CITY OF ALBUQUERQUE

March 14, 2019

**Re: Maverik – 5001 Jefferson NE
Erosion Sediment Control Plan
Engineer's Stamp Date 3-5-19 (F17E044C1)**

MAVERIK 5001 JEFFERSON ST. NE SWPPP PLAN AND ESC PLAN	DRAWN BY RS
	DATE 3/4/2019
 TIERRA WEST, LLC 5571 MIDWAY PARK PLACE NE ALBUQUERQUE, NM 87109 (505) 858-3100 www.tierrawestllc.com	2018056-SWPPP
	SHEET # SW1
	JOB # 2018056

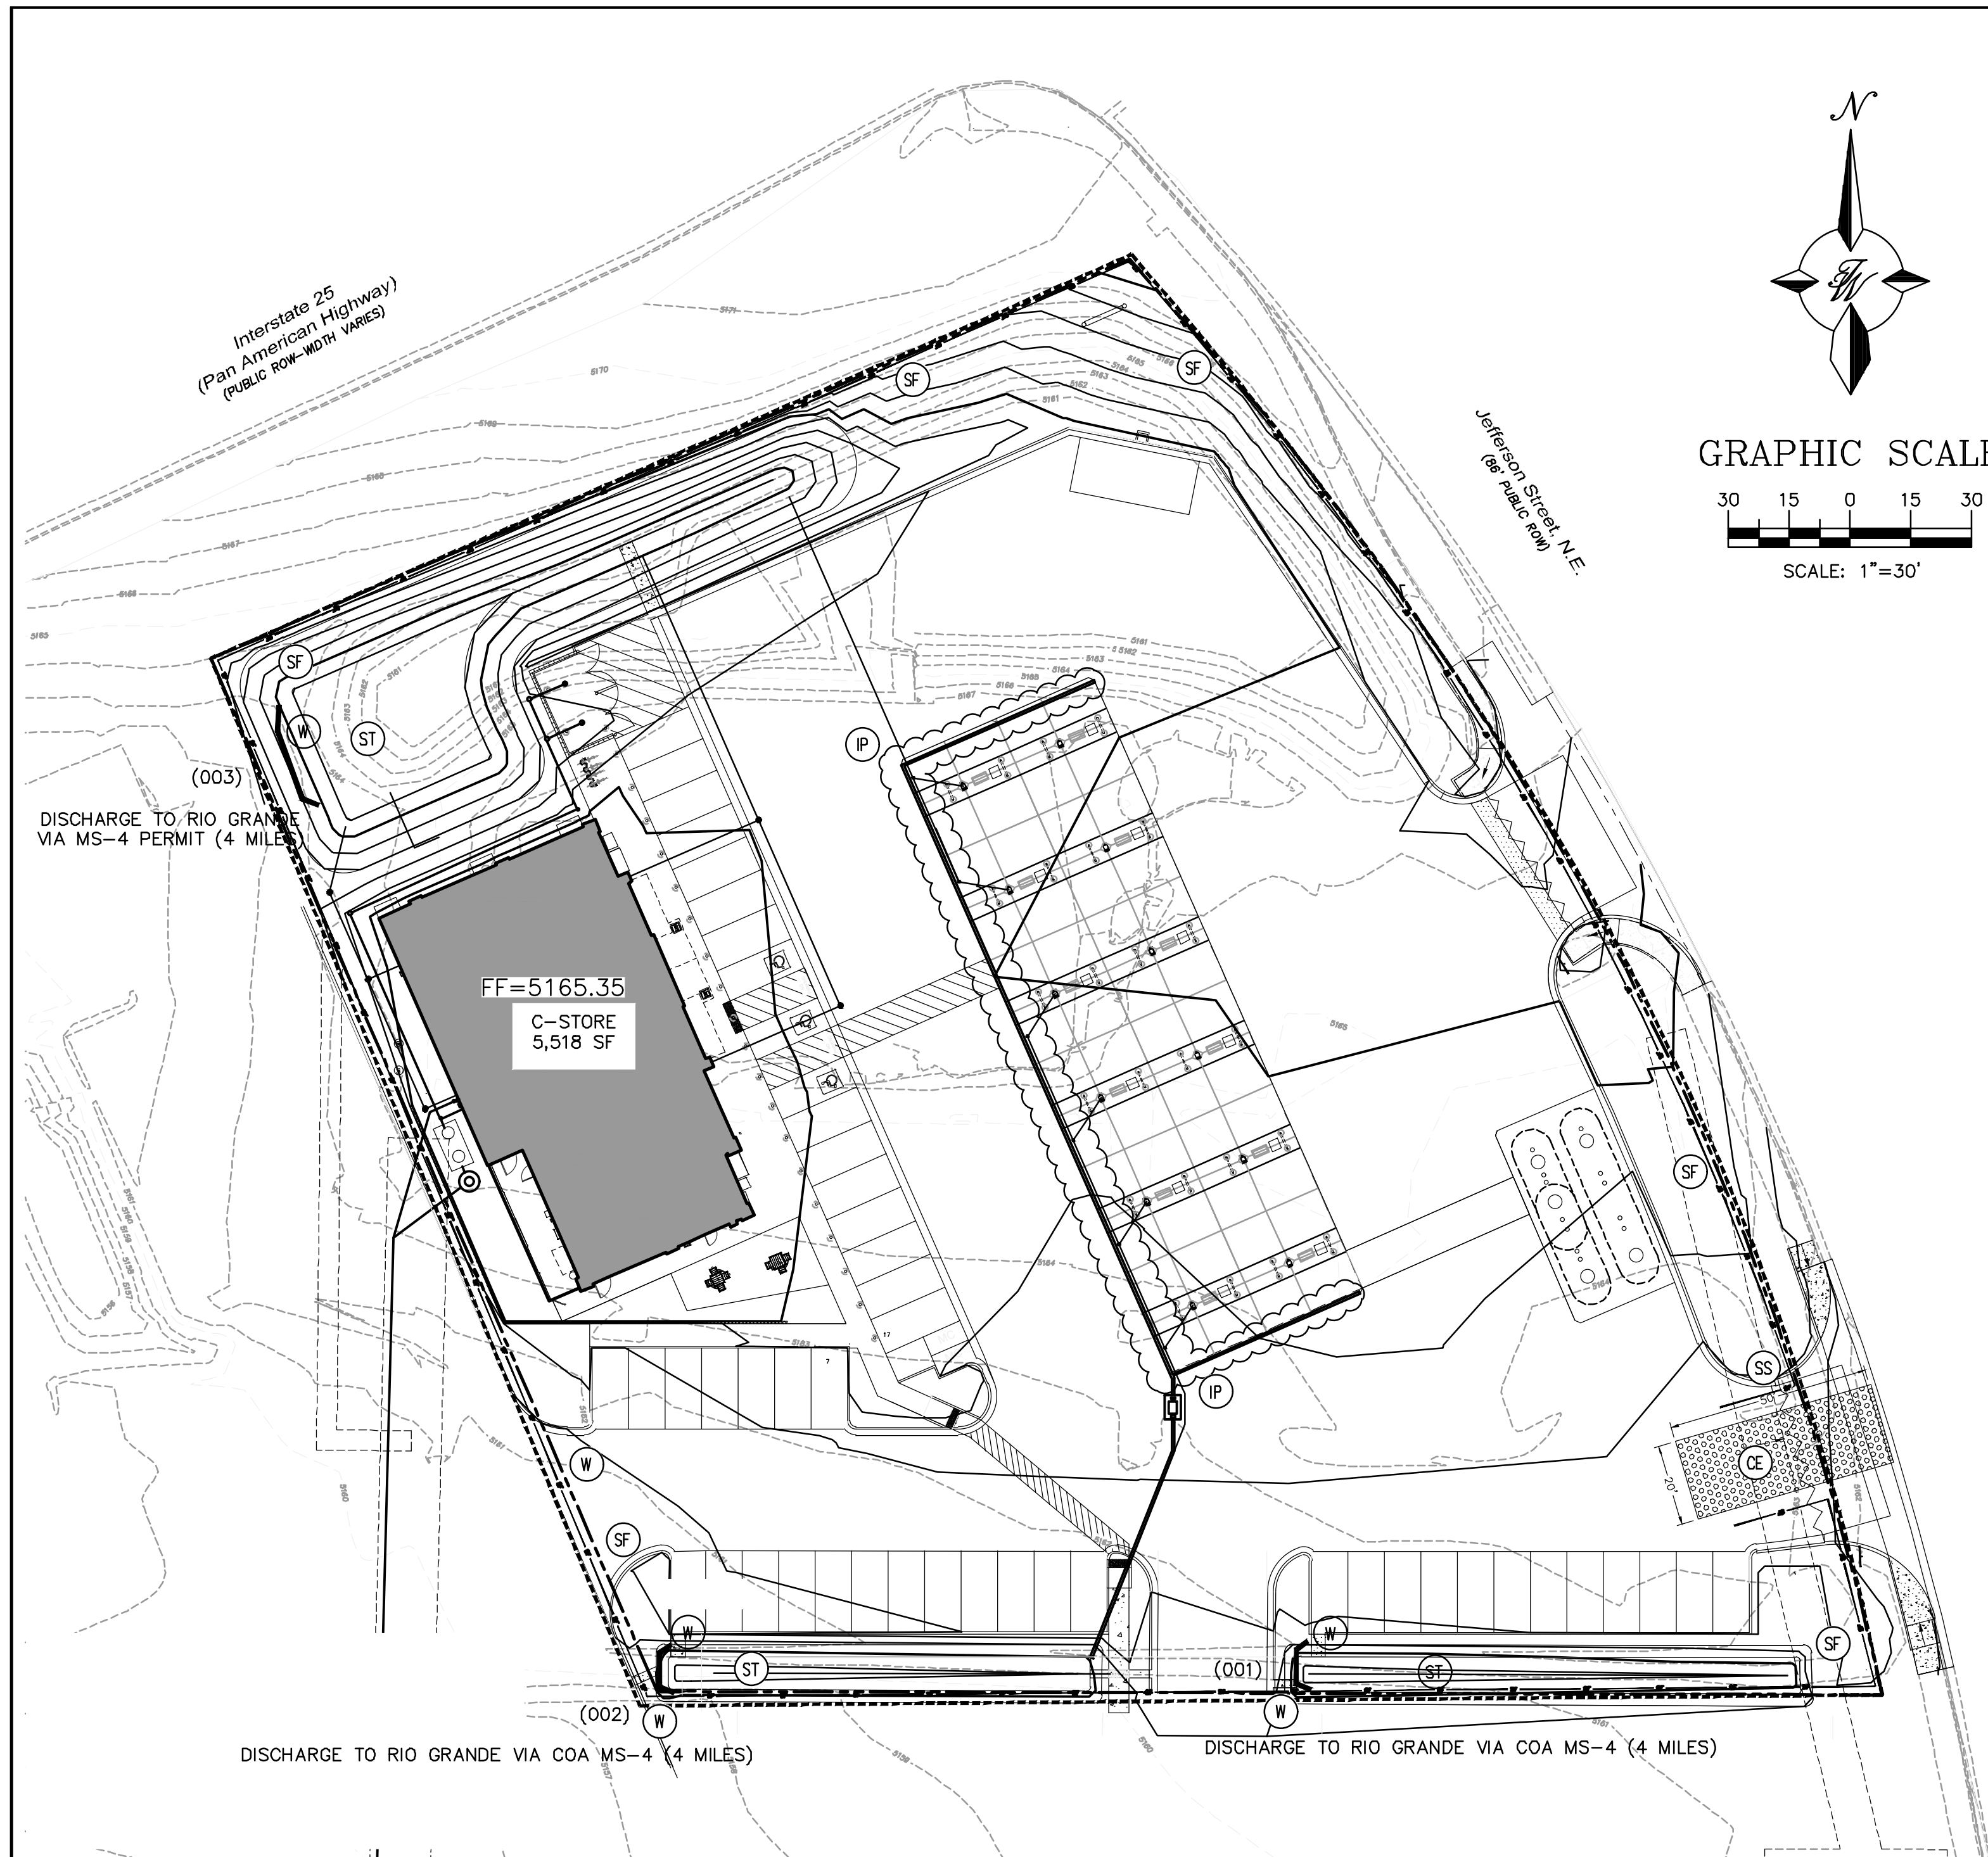
In the future, include proposed grades on the plan. Proposed grades had to be transferred from the grading plan to this plan.
